HANNAH RIDGE AT FEATHERGRASS FILING NO. 7

A REPLAT OF TRACT LL OF HANNAH RIDGE AT FEATHERGRASS FILING NO. 1, RECEPTION NO. 214713468, RECORDS OF EL PASO COUNTY, COLORADO AND TRACT A AS PLATTED IN HANNAH RIDGE AT FEATHERGRASS FILING NO. 6, RECORDED UNDER RECEPTION NO. _____, SECTION 32, TOWNSHIP 13 SOUTH, RANGE 65 WEST OF THE SIXTH PRINCIPAL MERIDIAN, EL PASO COUNTY, COLORADO

HANNAH RIDGE AT FEATHERGRASS FILING NO. 7
JOB NO. 1116.07
OCTOBER 4, 2018
SHEET 1 OF 3
OWNER: FEATHERGRASS INVESTMENTS, LLC
4715 NORTH CHESTNUT STREET, SUITE 200
COLORADO SPRINGS, CO 80907

HANNAH RIDGE AT FEATHERGRASS FILING NO. 7

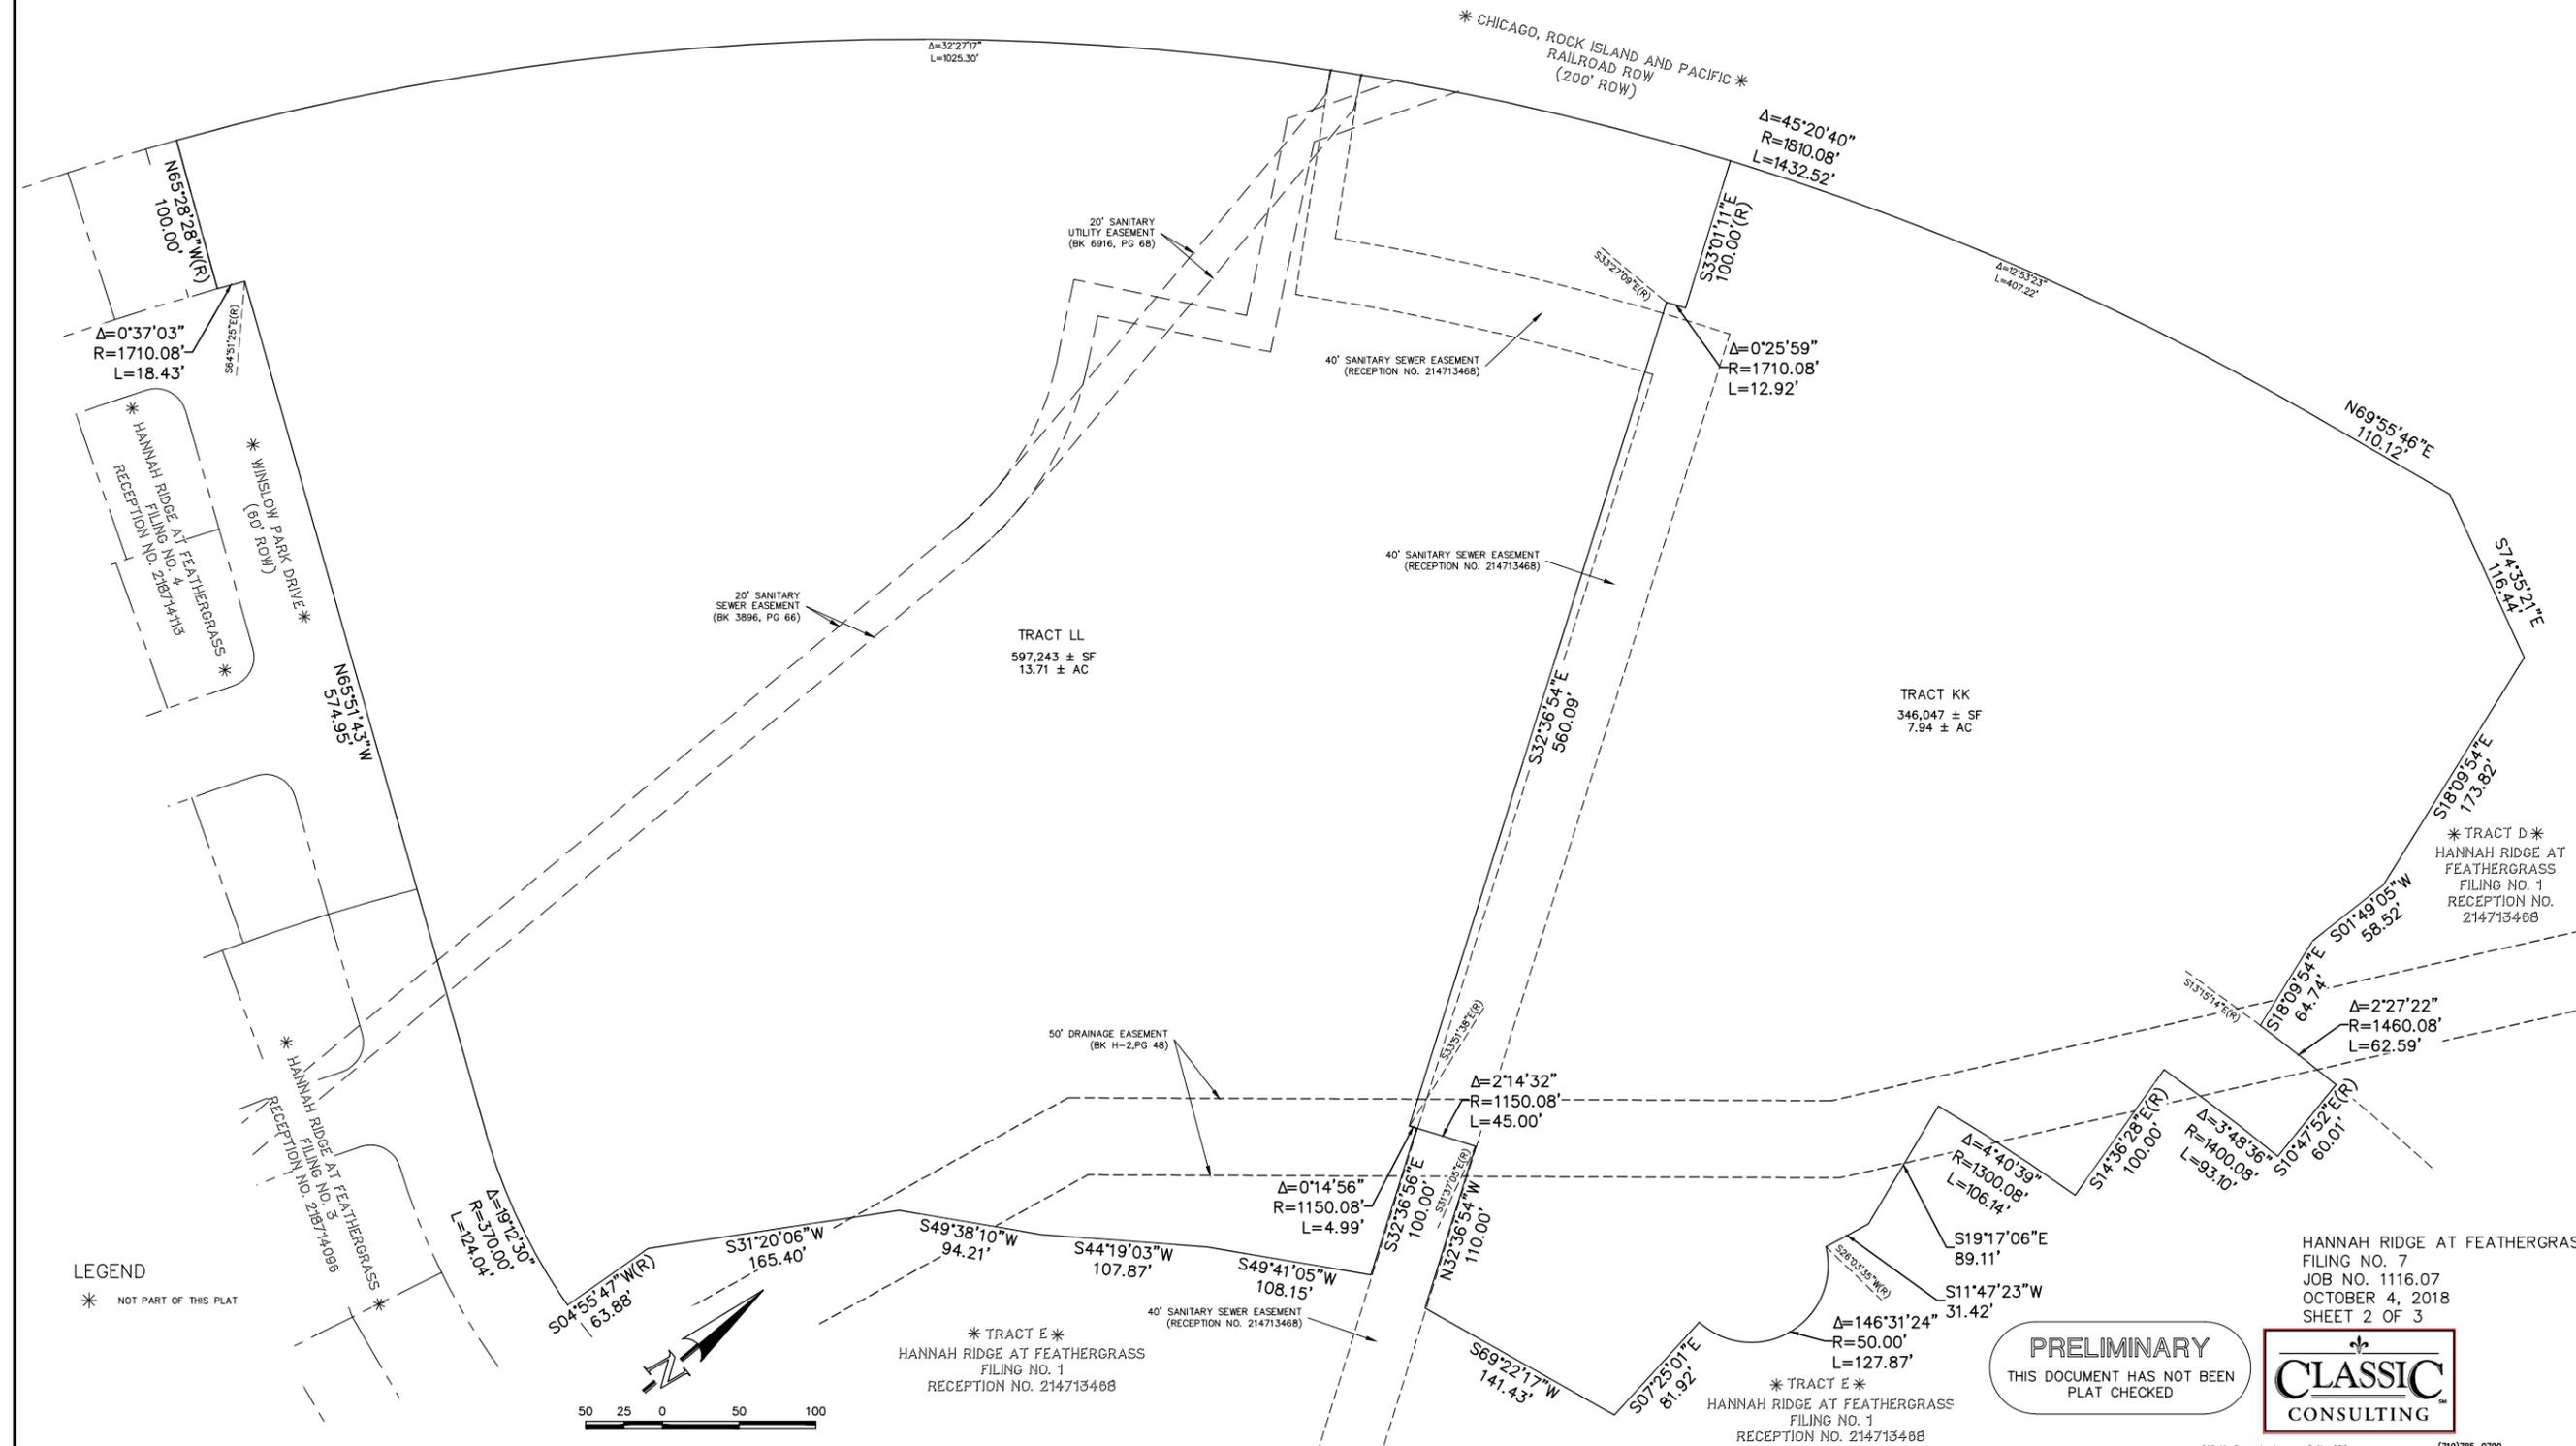
define the outer subdivision line boundary with a thicker or different line type. It is difficult to depict lot lines from boundary

HANNAH RIDGE AT FEATHERGRASS
FILING NO. 7
JOB NO. 1116.07
OCTOBER 4, 2018
SHEET 2 OF 3

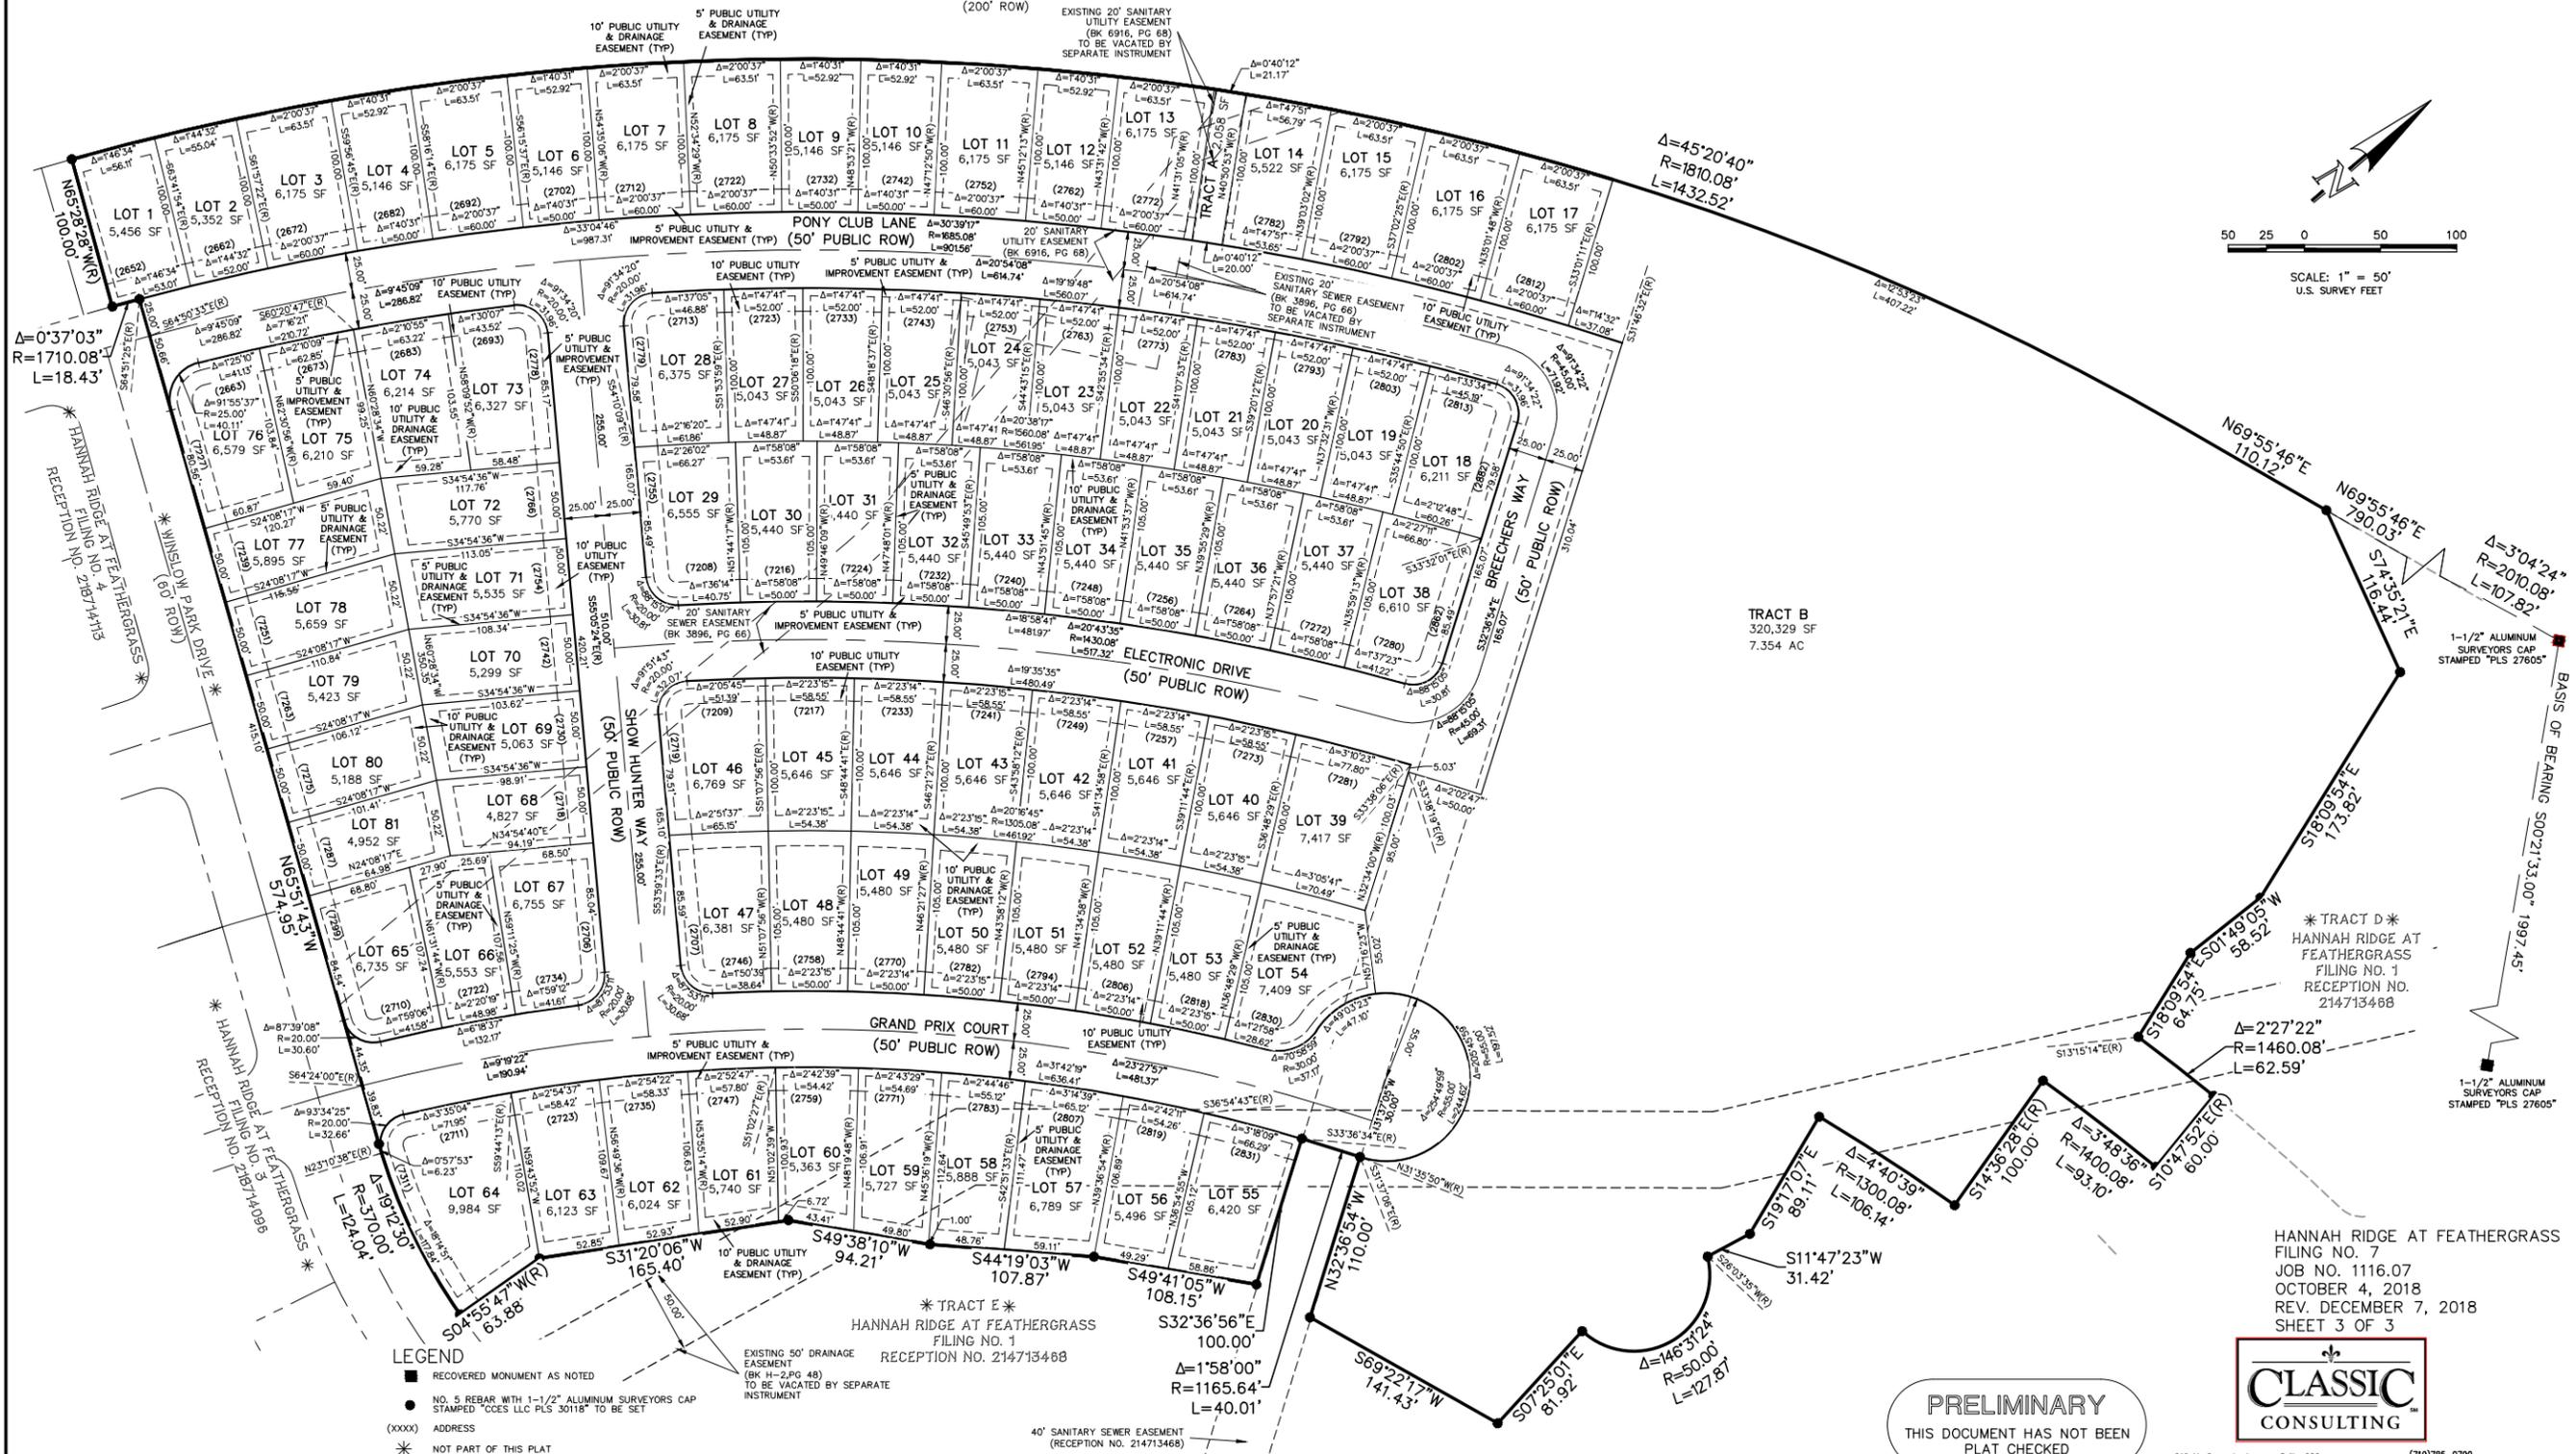
Where is the CIG
 easement? The title
 work identifies an
 easement. Is it going
 away?
 Please verify all
 encumbrances are
 shown and then
 identify if they are to
 be vacated
